**Re: Sunset Apartments at 8400 Sunset Gardens Rd. SW
Erosion and Sediment Control Plan
Engineer's Stamp Date 12/17/25 – L10E032 (SWQ-2026-00024)**

Based on the information in your submission received on 3/19/26, the ESC Plan and NOI can't be approved until after the following comments are addressed.

SUNSET APARTMENTS ALBUQUERQUE, NM	DRAWN BY RMG
	ESC PLAN	DATE 01-09-2025
	SHEET # ESC-1	DRAWING # 2022028_SWPPP
RONALD R. BOHANNAN P.E. #7868	5571 MIDWAY PARK PL NE ALBUQUERQUE, NEW MEXICO 87109 (505) 858-3100 www.tierrowestllc.com	JOB # 2022028

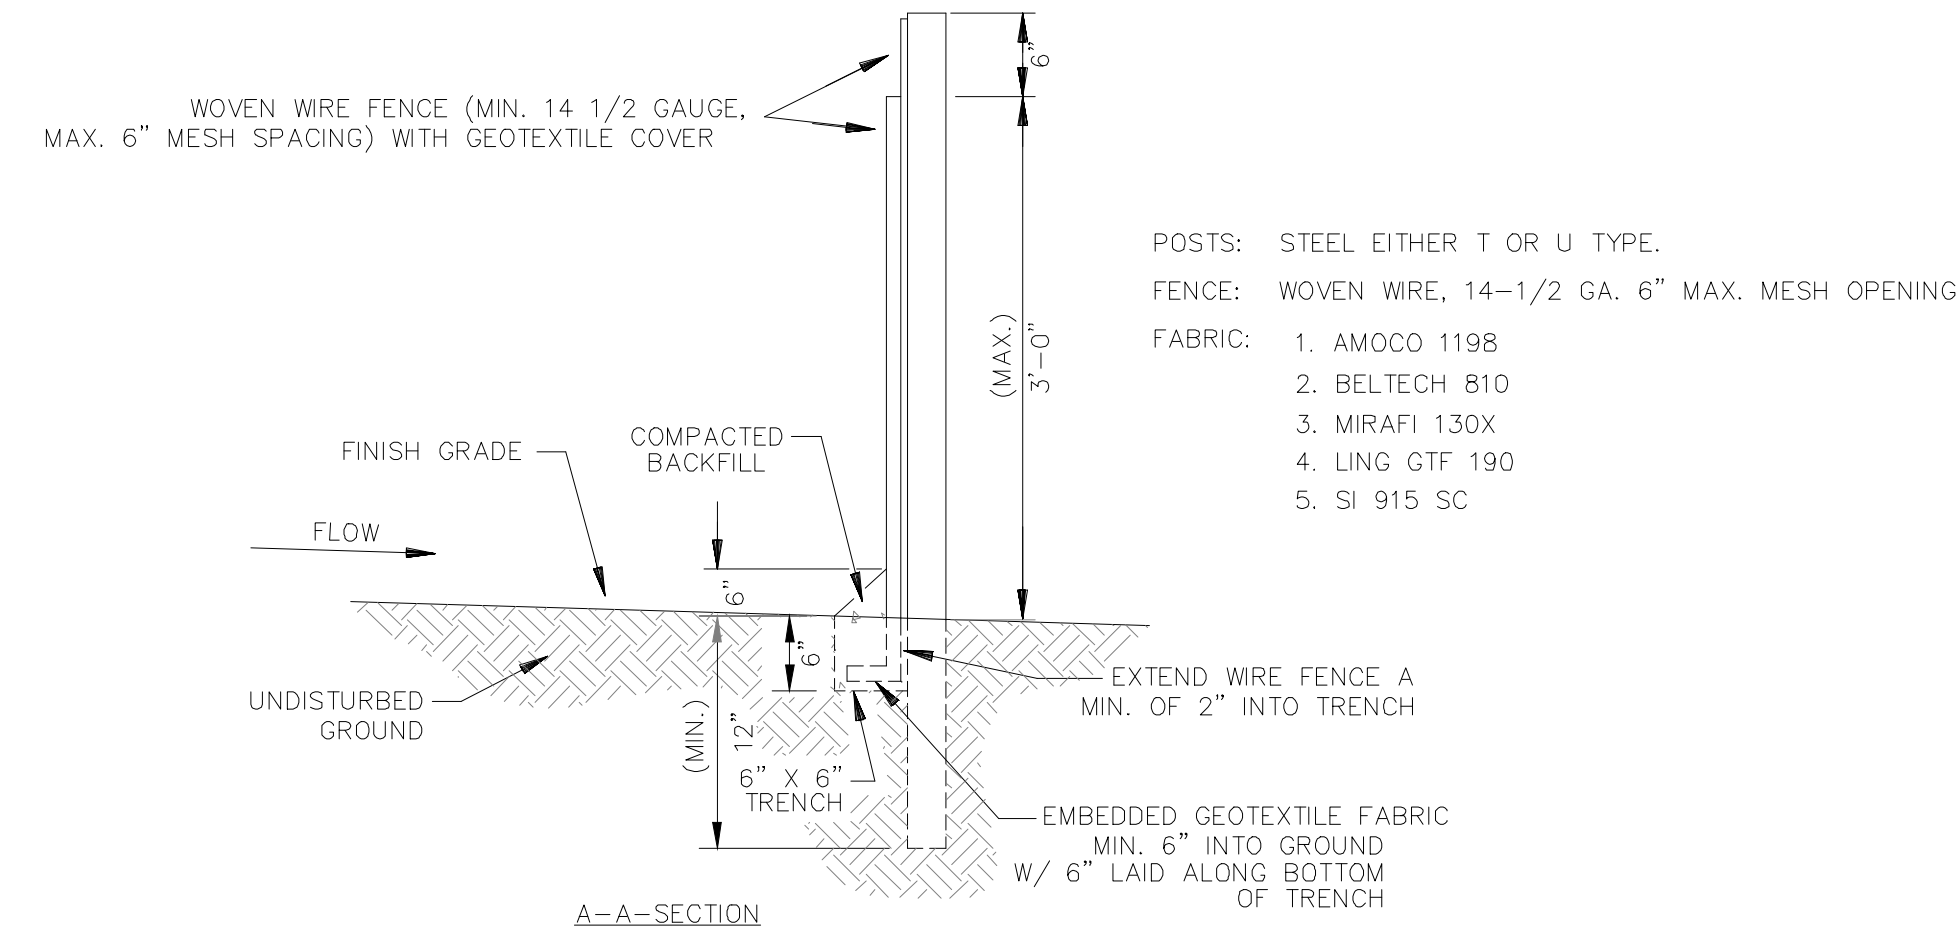
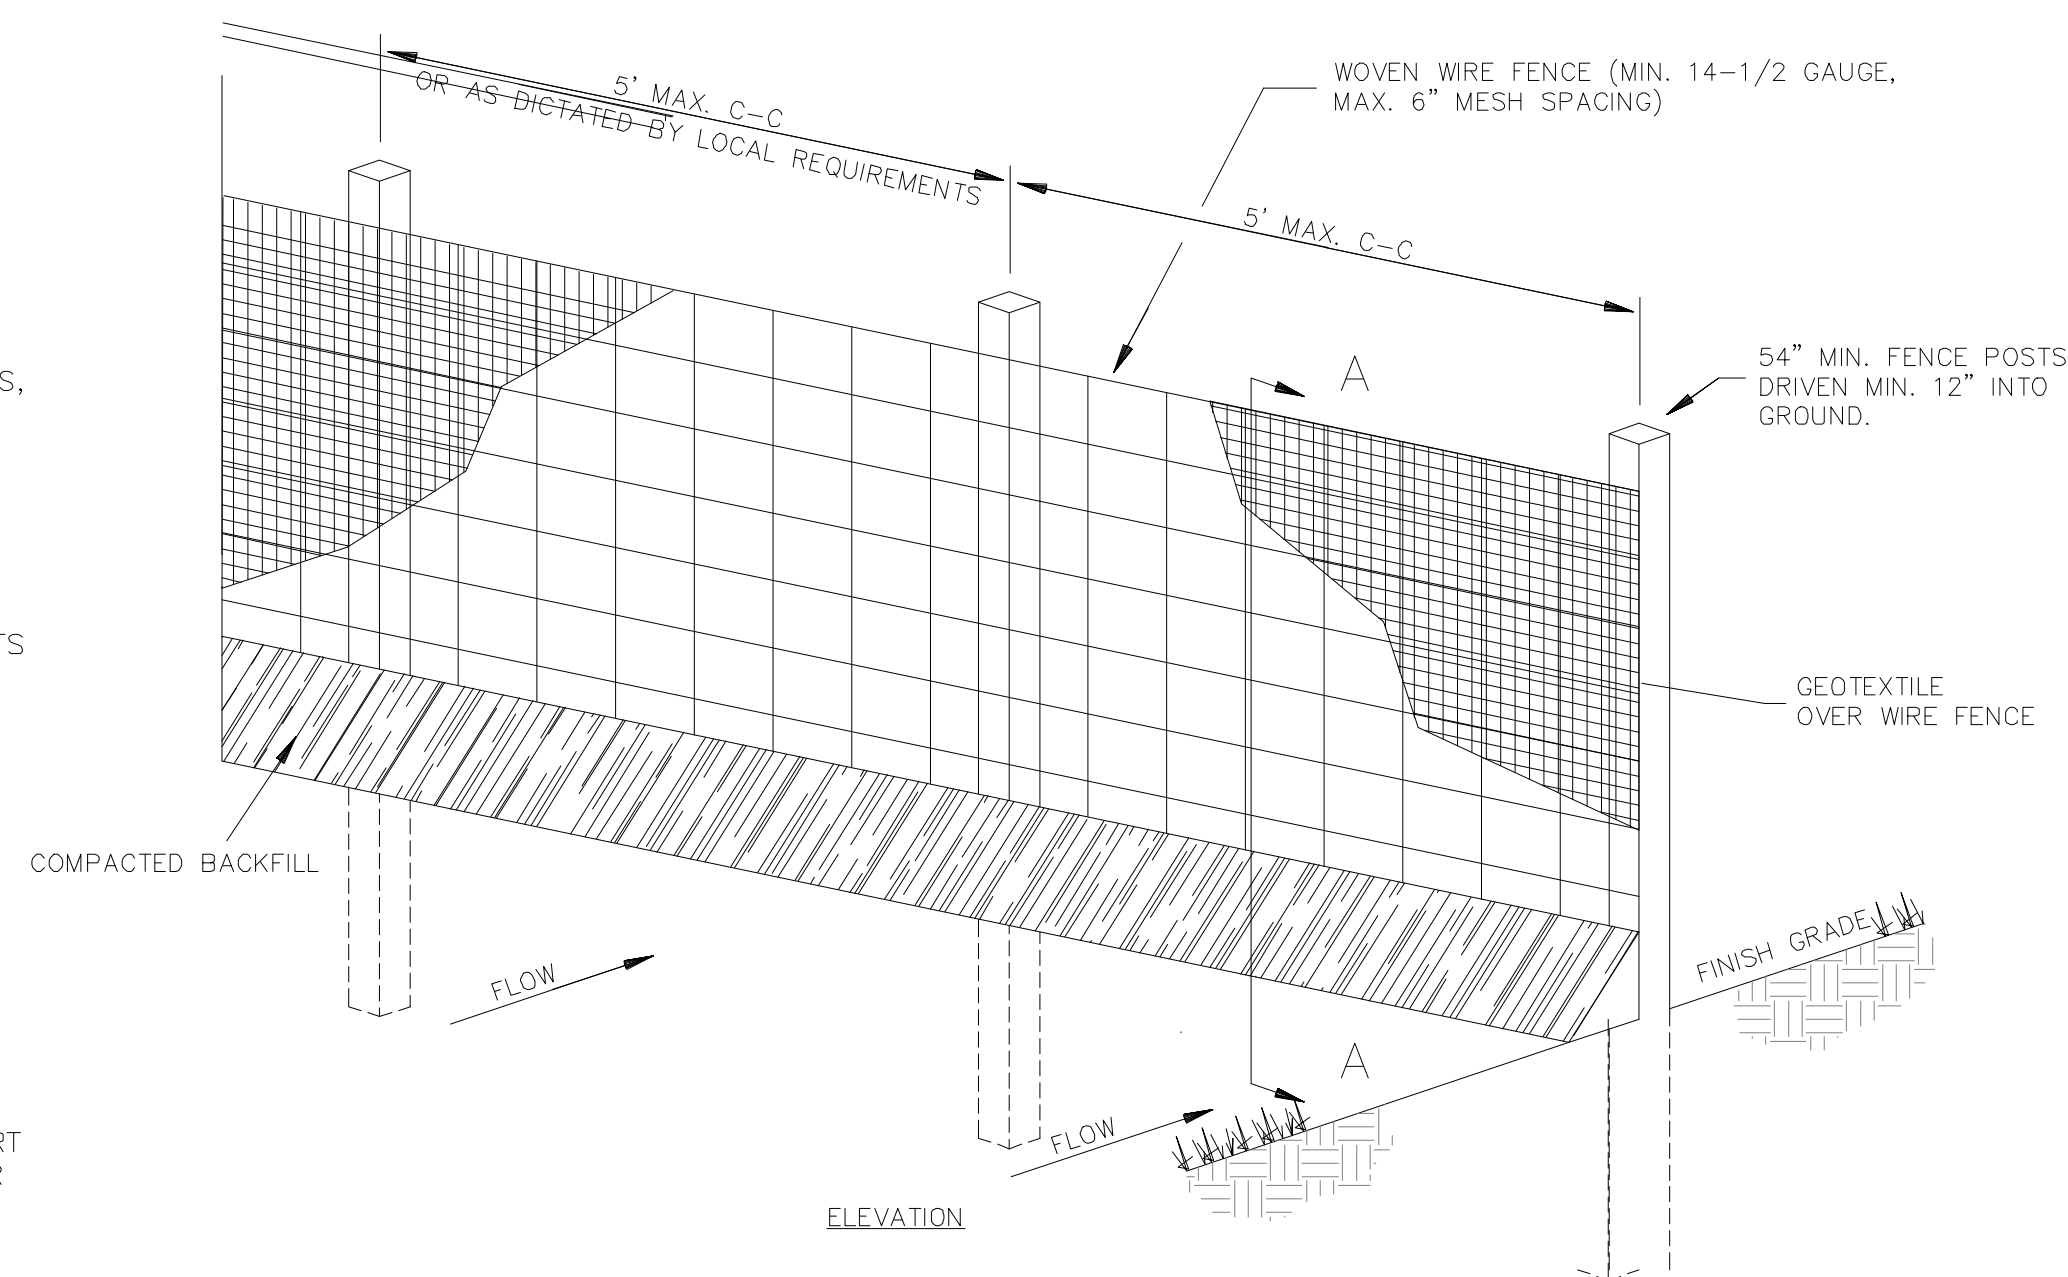
3. The symbols for silt fence are not legible (lettering too small, 0.1" min) and the scale of the plan is too small. Enlarge the views so that the grading detail is legible and increase the lettering height to 0.1" minimum.

4. The sediment traps (ST) shown on the plan appear to be too small and don't capture stormwater from all of the disturbed areas. Sediment Trap (ST) design calculations and construction specifications for the sediment trap geometry are missing and must include:

- a. Elevation, dimensions, and area of the bottom.
 - b. Cleanout elevation, area, and volume.
 - c. Elevation, area, and volume of the required volume.

- d. Overflow crest elevation, area, and volume (must include 1 foot freeboard above the required volume).
 - e. 100-year elevation, area, and volume (based on 100-year depth at spillway).

- f. Spillway dimensions, materials, and location.
 - g. Basin side slopes.
 - h. A table showing conic volume calculations.
 - i. A profile through the outlet, labeling these elevations.

5. It appears that stormwater will flow out of the east driveway and two swales on the north without entering the ST. Add diversion channels (DC) to direct stormwater into the STs from the disturbed area of Sunset Gardens right-of-way and to prevent stormwater from leaving the site on the north, south, and east sides during construction.
